Our Ref: TR010038

Date: 12 April 2021

Application by Highways England for an Order Granting Development Consent for the proposed A47 North Tuddenham to Easton

Advice following issue of decision to accept the application for examination

DRAWING TITLE					
TRAFFIC REGULATIONS PLANS REGULATION 5(2)(o) SHEET 14 OF 23					
SUITABILITY					
AUTHORISED AS STAGE 3 COMPLETED					
SHEET SIZE		SCALE		STATUS	
A1		1:1250		A3

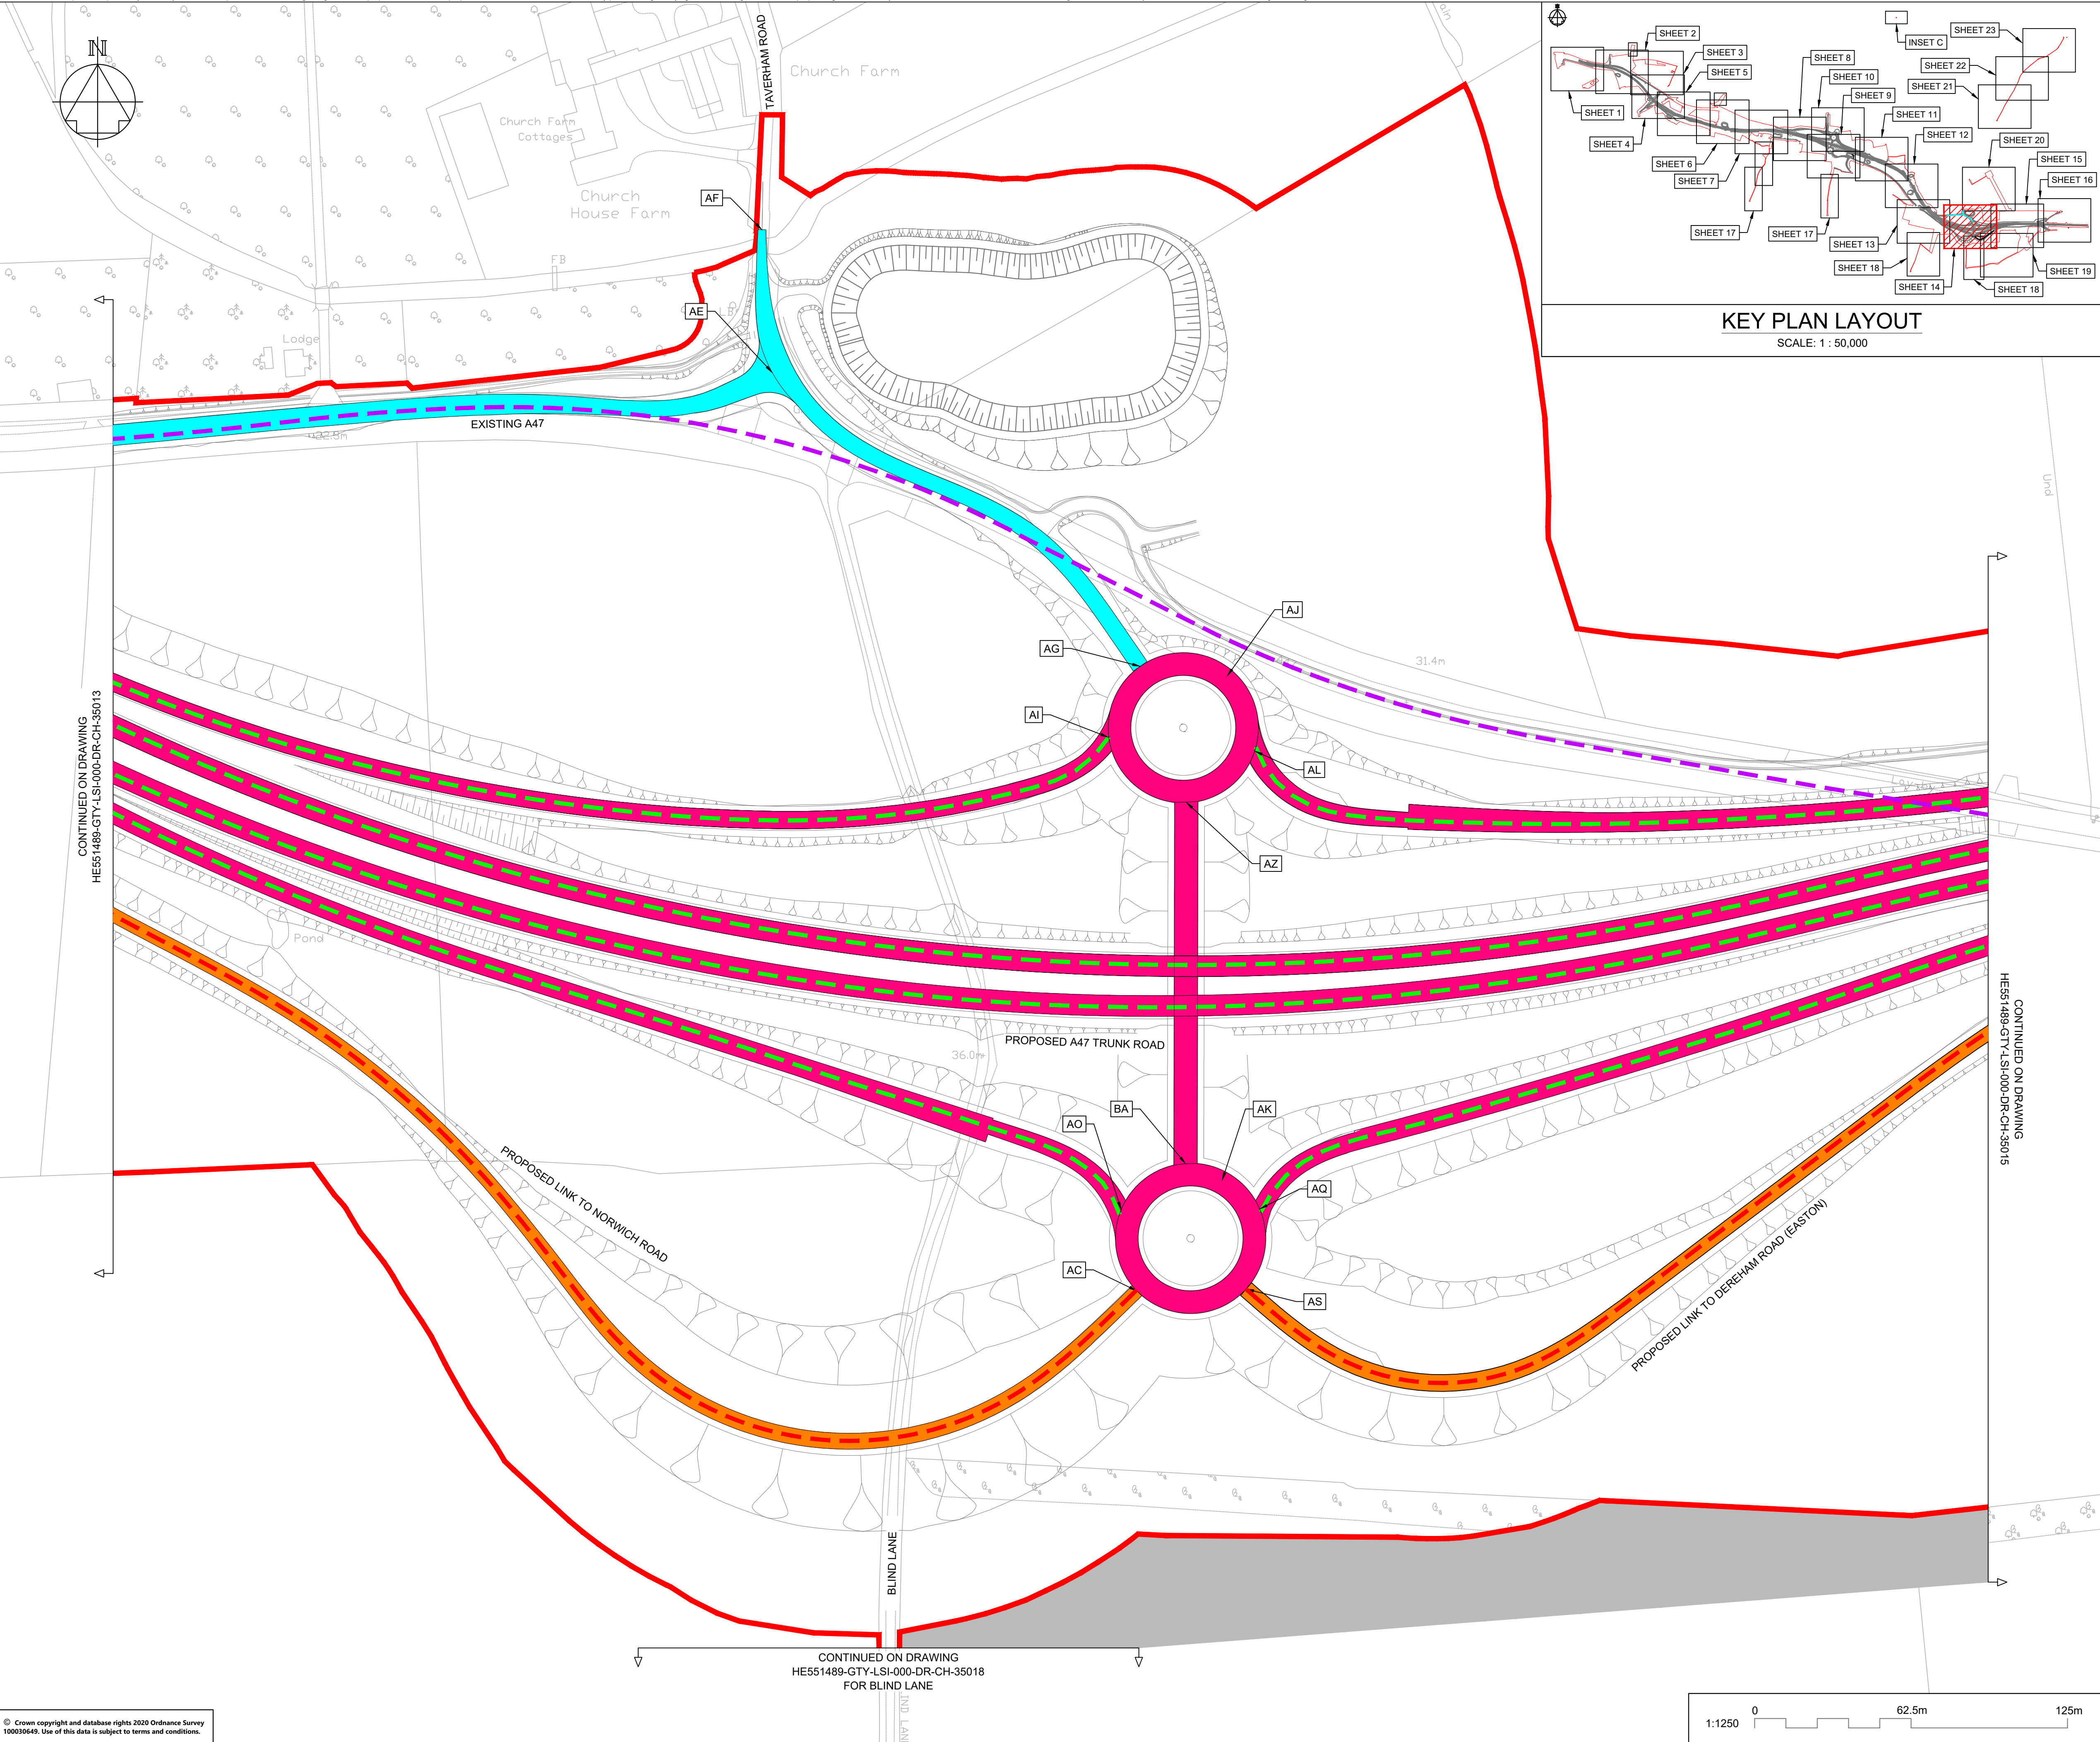
- o Some of the points on sheets 14, 15 and 17 of the traffic regulation plans are not mentioned in the descriptions.

- Some of the sheets are missing north arrows.
- There are two points AZ, on sheets 2 and 14. Only the AZ on sheet 2 is referred to in the dDCO.
- Point G is not on sheet 7, as stated in the dDCO.
